Recommendation Report for Planning Permission for Works or Extension to a Dwelling

REF NO: BN/39/26/HH

LOCATION: 19 Elm Grove
Barnham
PO22 0HJ

PROPOSAL: Erection of open sided car port with tiled roof to match existing dwelling.

FOR MR & MRS D. HARVEY		
SITE 19 ELM GROVE, BARNHAM, WEST SUSSEX. PO22 0HJ		
TITLE PROPOSED CAR PORT FLOOR PLAN & ELEVATIONS		
SCALE AS SHOWN	DRAWN AH 02/26	DRAWING NO. 24 REV A

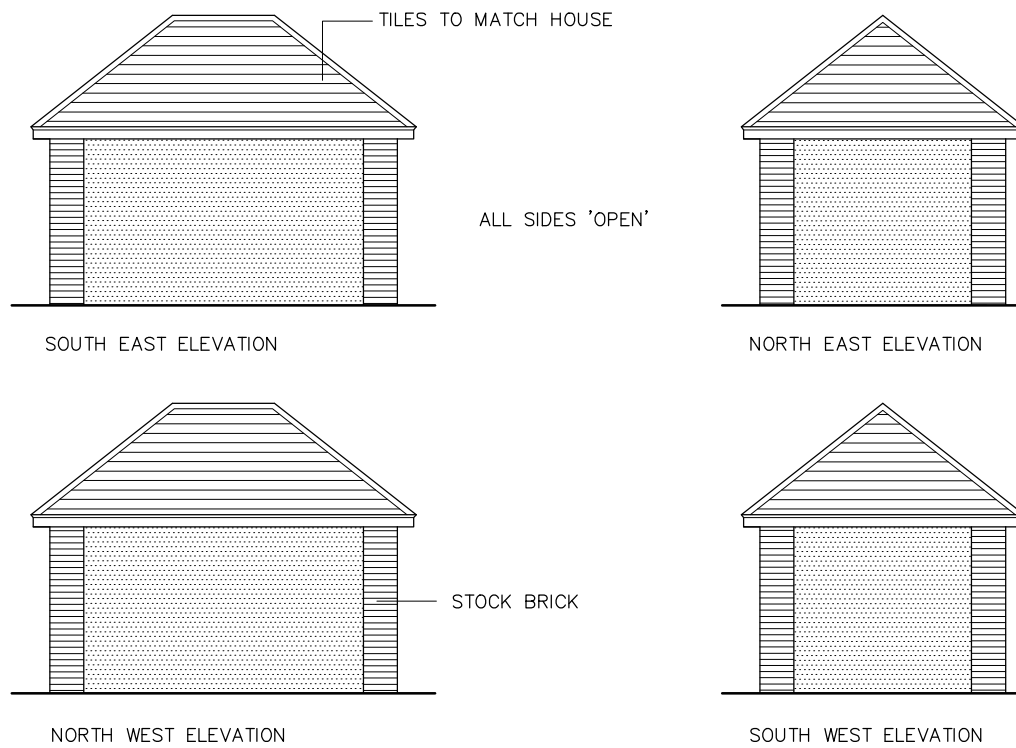
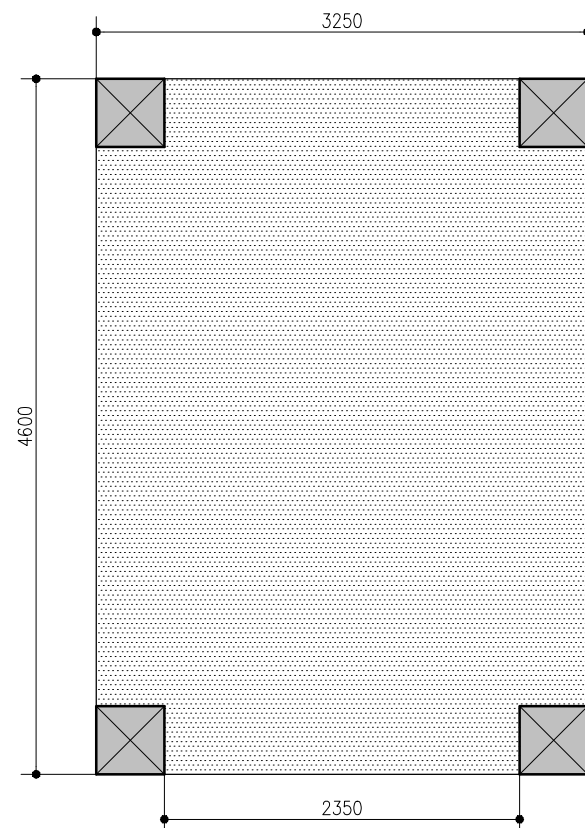
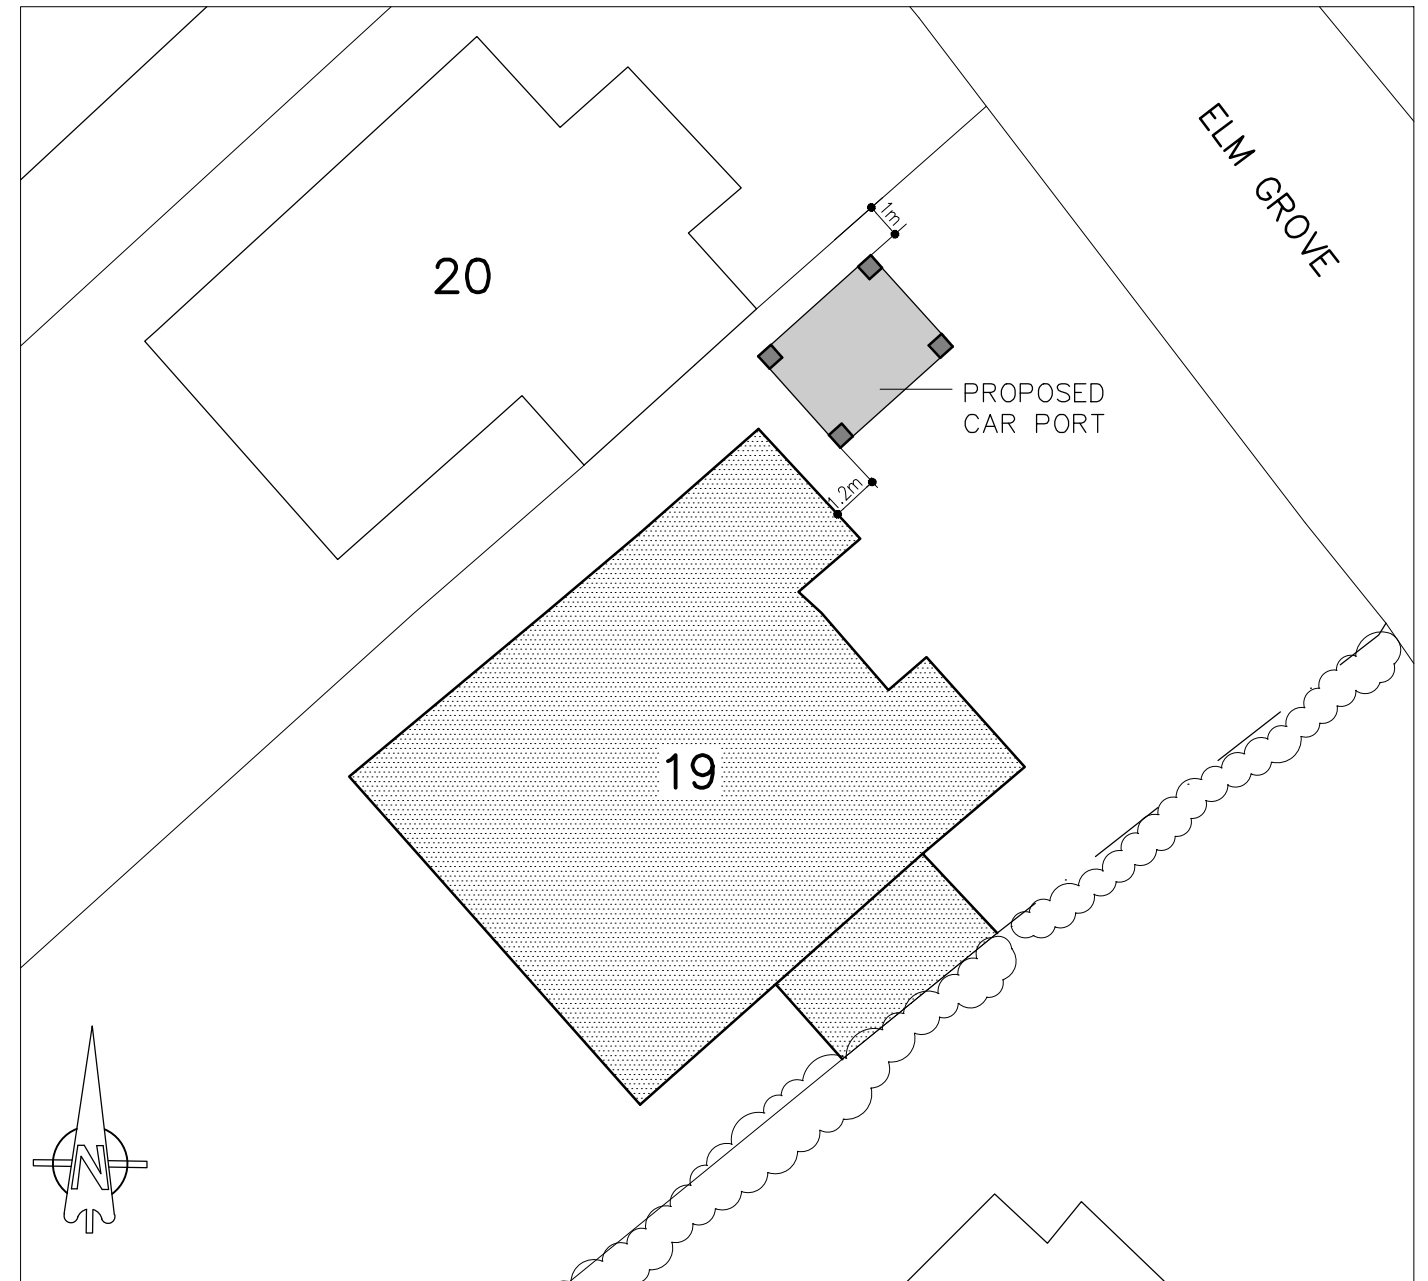
0.1.Insufficient information regarding surface water drainage has been submitted to evidence that flood risk will not be increased as due to the proposed development.

1.1.It is proposed to collect rainwater from the roof of the car port in water butts for re-use. Whilst this complies with Standard 1 of the Non-Statutory Technical Standards for SuDS (NSfS) it will rarely provide a whole design solution, as during the wettest months, when the need for water would significantly fall, water butts would fill to capacity. As, when water butts were at capacity no final discharge location has been confirmed, insufficient evidence has been submitted to demonstrate how the applicant intends to drain surface water, we are unable to assess whether the proposed development would increase flood risk. It is the responsibility of the applicant or their drainage designer to provide this evidence. For this reason, we object to the proposal, as the submission of such evidence may affect the scale and layout of the development.

1.2.To support an infiltration-based design, winter groundwater monitoring must be undertaken to confirm that a minimum of one metre of unsaturated ground can be maintained between the base of the soakaway or infiltration structure and the peak groundwater level. Ground conditions and infiltration potential in Barnham are highly variable. While infiltration may be feasible in some areas, others experience high groundwater levels or poor infiltration rates that render it unviable. This must be robustly demonstrated by the applicant. Further information regarding infiltration testing and groundwater monitoring can be found at <https://www.arun.gov.uk/surfacewater/>.

The Drainage Engineers have objected on the grounds that no surface water runoff location has been provided, as required by Standard 1 of the Non-Statutory Technical Standards for SuDS (NSfS).

In this instance, the car port would be an open structure, constructed over an area of existing hard standing and would not result in an increase in impermeable or hard surfaces within the application site.

The proposed development would not result in an increase in the risk of flooding elsewhere and is in accordance with Arun Local Plan policies W DM1 and W DM3.
